**RE: Sawmill Market
1909 Bellamah NW
Grading and Drainage Plan
Engineer's Stamp Date: 10/22/18
Hydrology File: J13D017A**

Based on the submittal received on 10/23/18, the Grading and Drainage Plan cannot be approved for Building Permit and SO-19 Permit until the following corrections are made:

PLAN

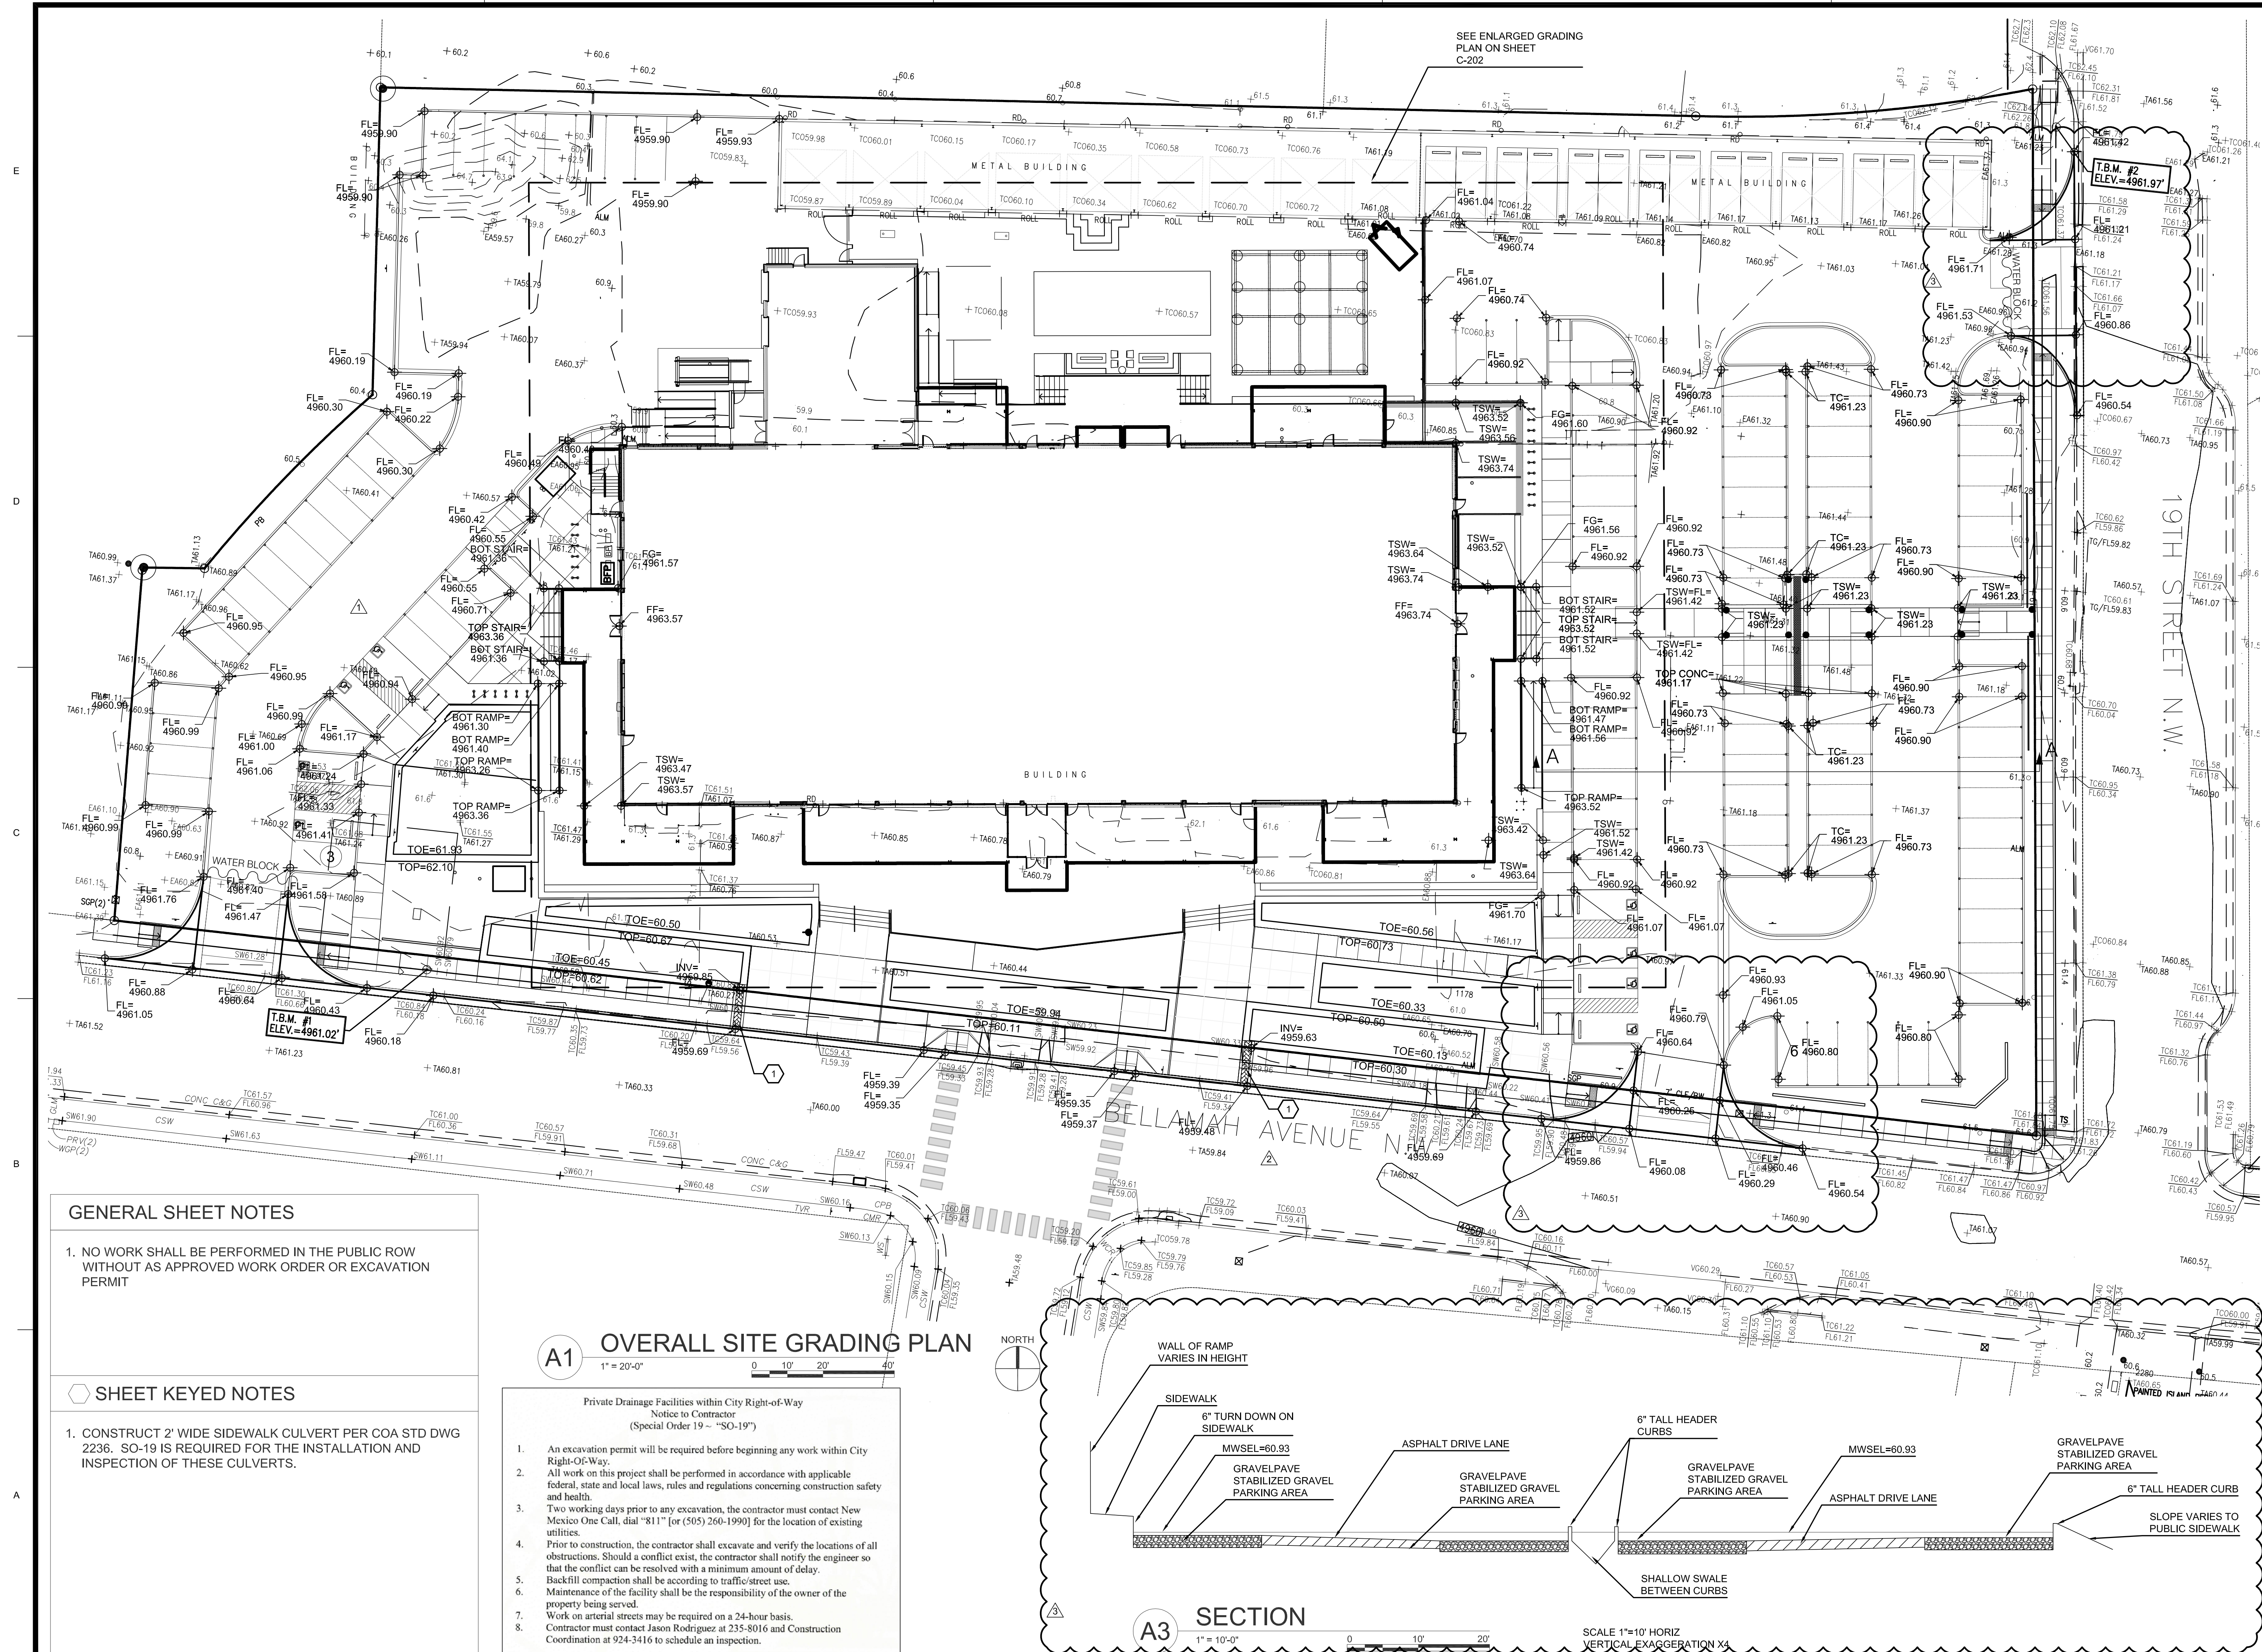
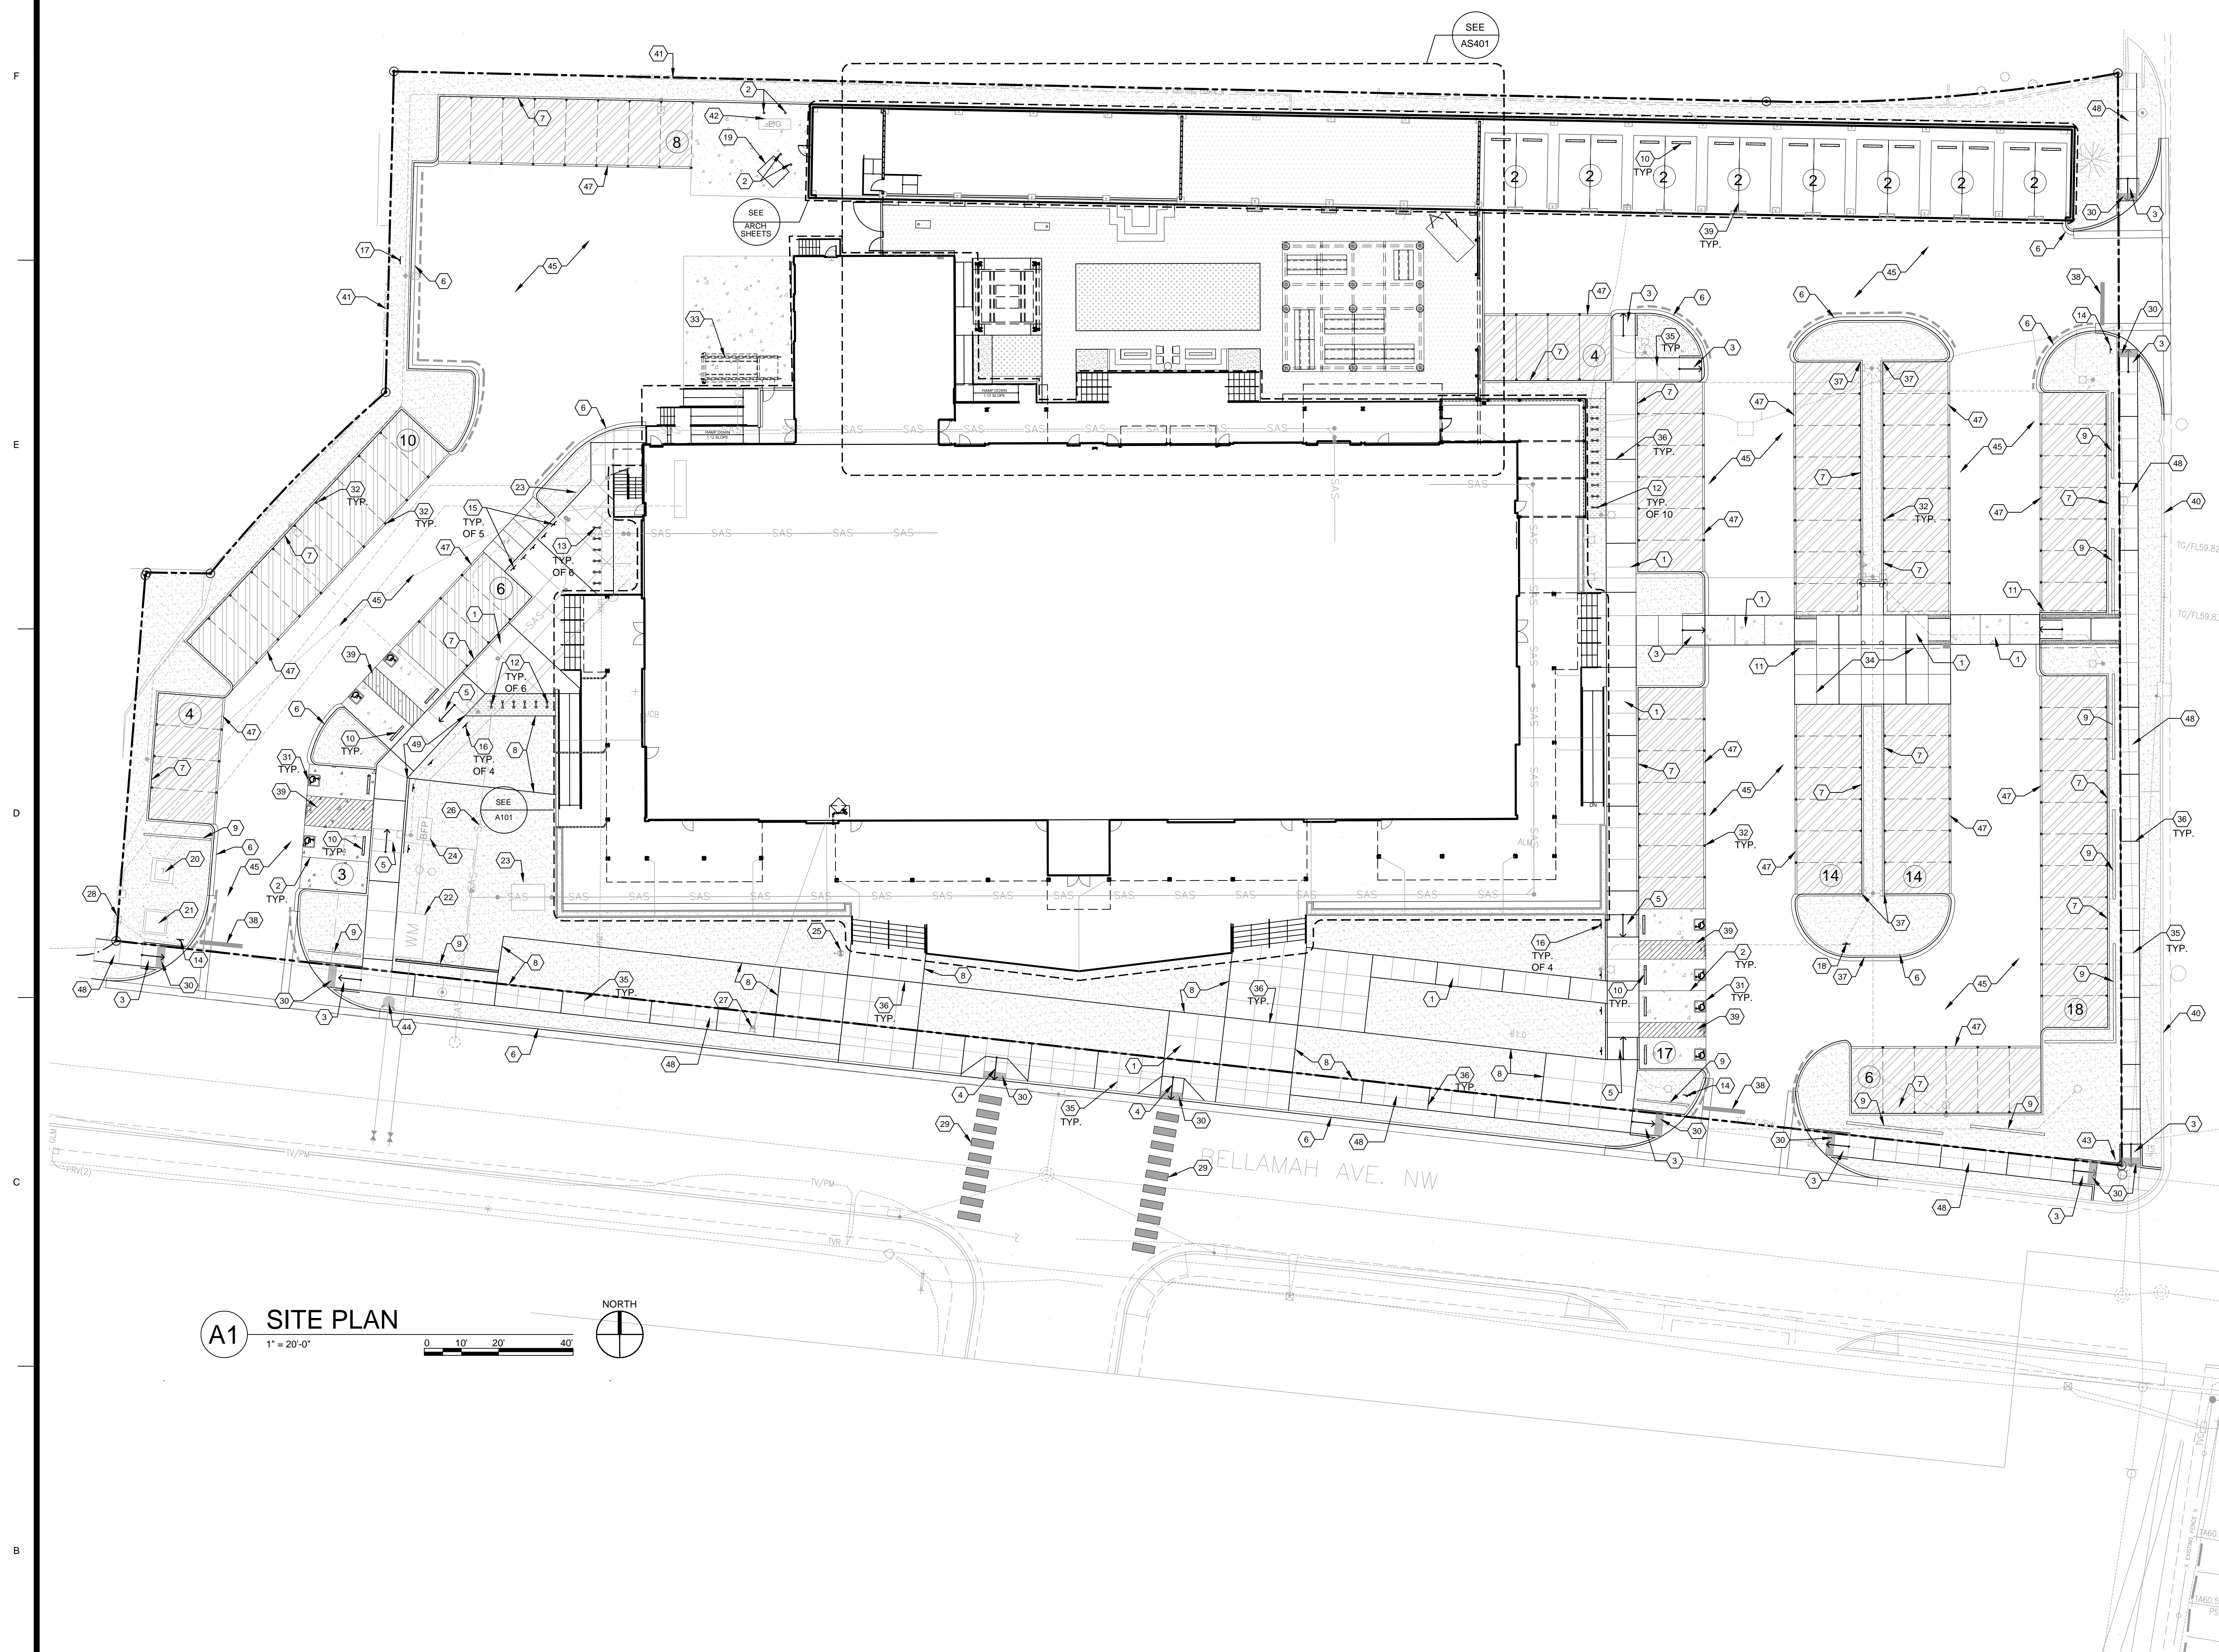
1. The ponds described on the drainage plan need to be shown on the grading plan, supported with top of pond elevations, and bottom of pond elevations.
2. Build notes for the areas of new paving, paving to remain, gravel-pave, and concrete work also need to be provided on the grading plan. Alternatively, if a separate paving plan was prepared to describe this work, please provide it.
3. Provide/show waterblocks on the NE and SE curb cuts. The spot elevation should show the maximum height, flowline in the public road, and show that the paved drive aisles slope back from the high point to retain the first flush volume. Please include the finished floor elevation of the building(s) and make sure the waterblocks will overtop first in the event they need to be used as an emergency overflow.
4. Provide a section/detail on the grading (or paving) plan for the gravel-pave parking/ponds.
